CLOSURE REPORT

JOB NUMBER: 20-74,782
 DRAWN BY: S. SILVA
 DATE: SEPTEMBER 24, 2020

Closures Sheet_V1.pdf Markup Summary

SHEET 1 OF 2

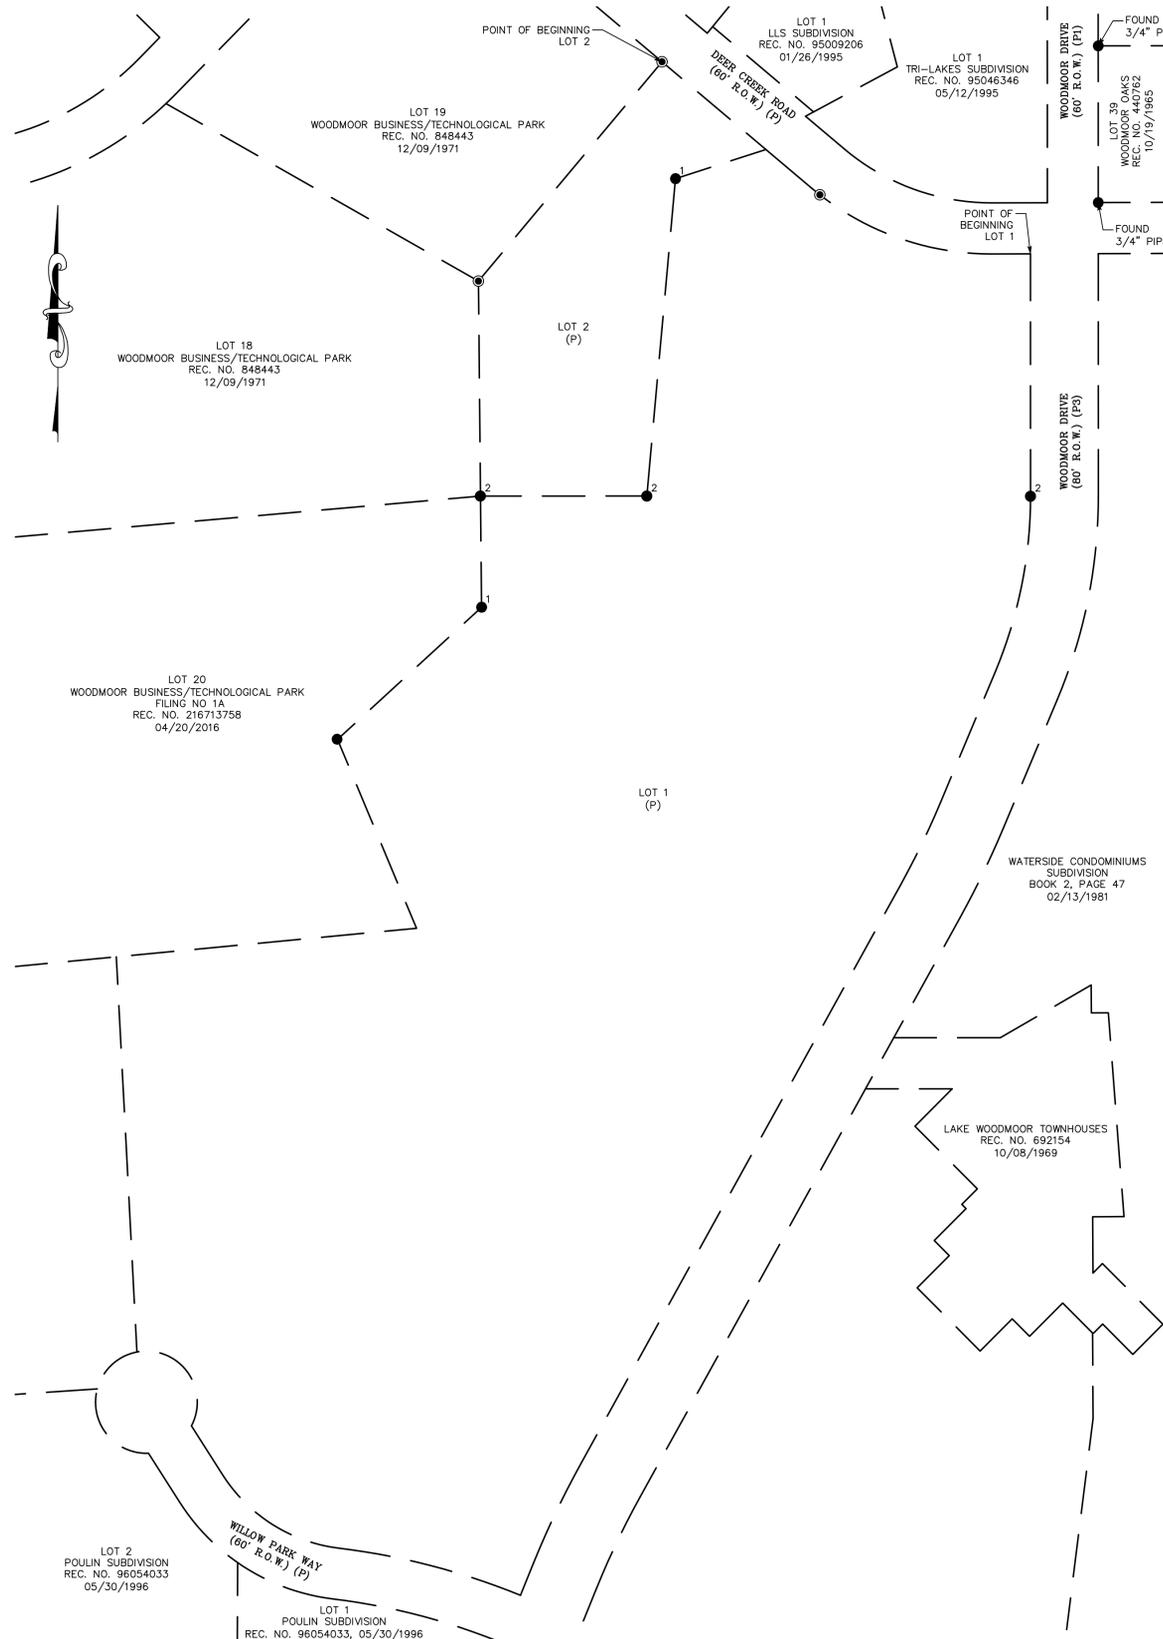
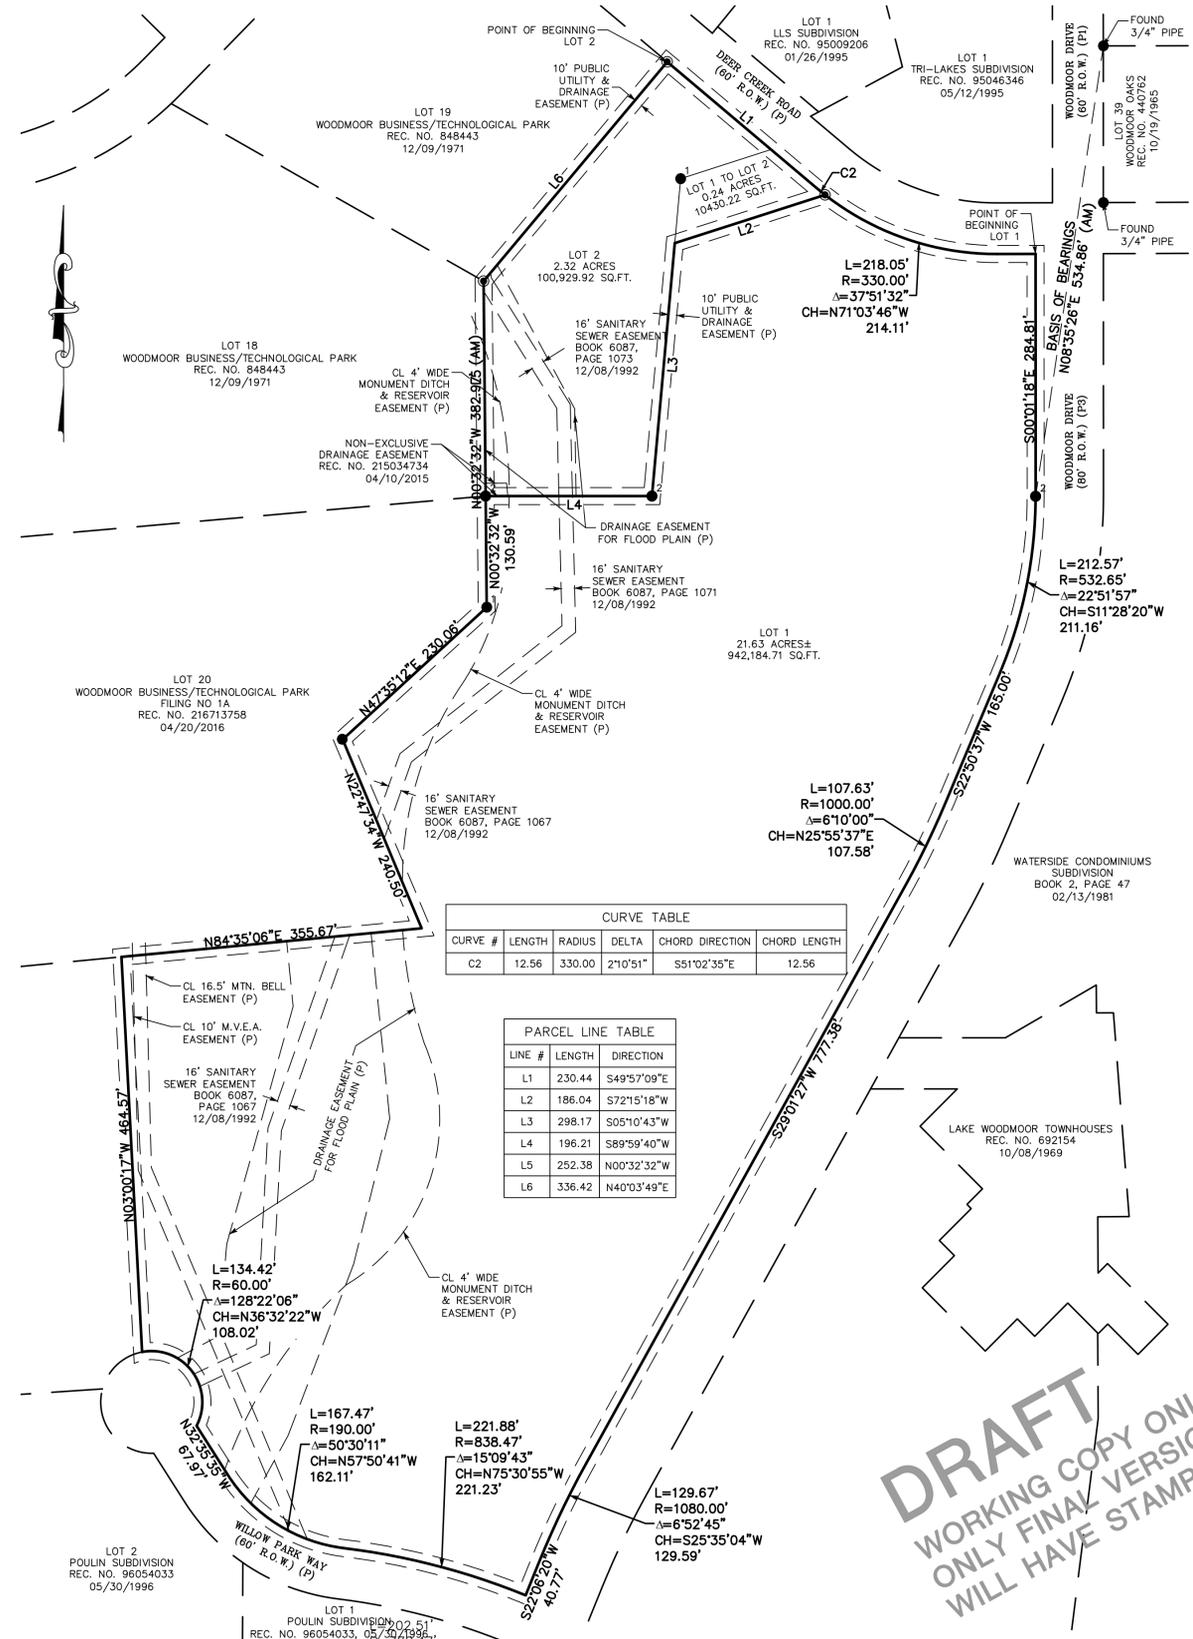
Bearings on proposed plat do not match those on the existing plat, as such this closures report will also need to be revised accordingly.
